**Town & Country Planning Act 1990 (as amended) s211 Notice
Application for Prior Notification of Work to Tree(s) in a Conservation Area**

Development Various tree surgery within Main Road/ Church Road Yapton conservation area

Location Yew Tree Nursing Home North End Road Yapton

PROPOSED LANDSCAPE PLAN
1:100

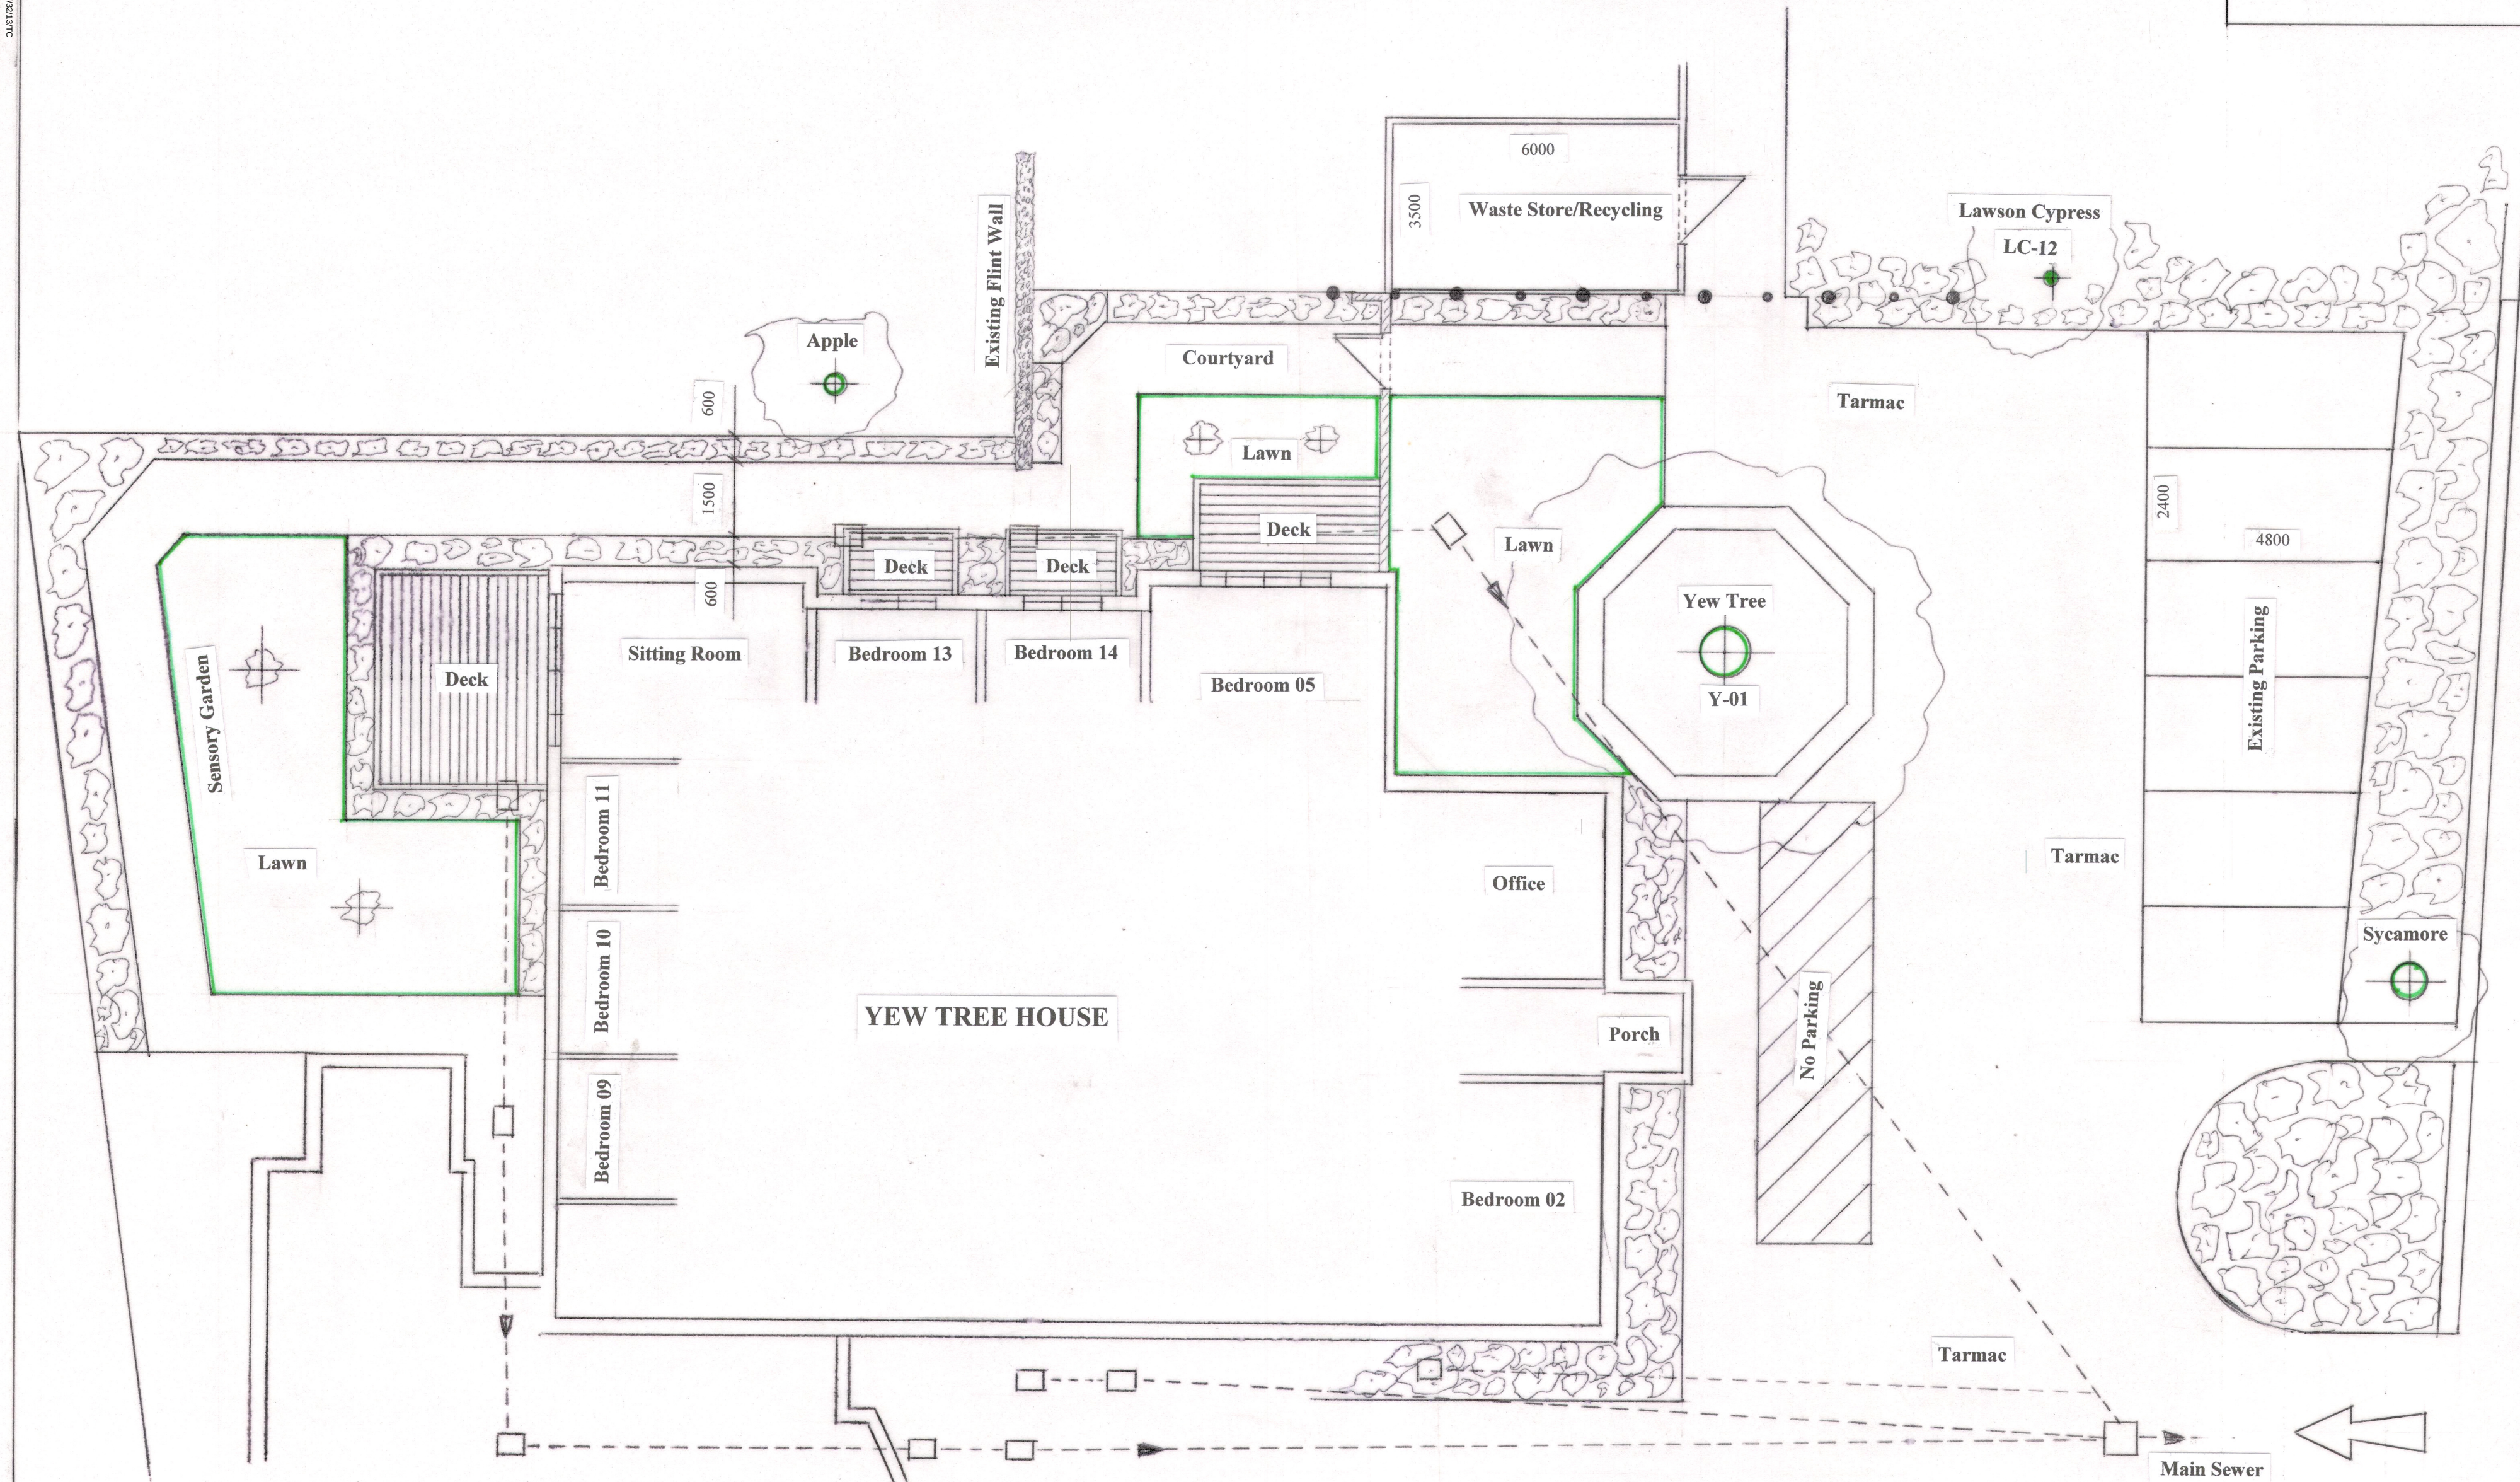
Please provide measurements of the reduction in length of the sides of branches of the Yew tree.

Please provide more details/ sketch of the tree you wish to retain (LC-12) which you propose to slightly remove and off set from old hedge line.
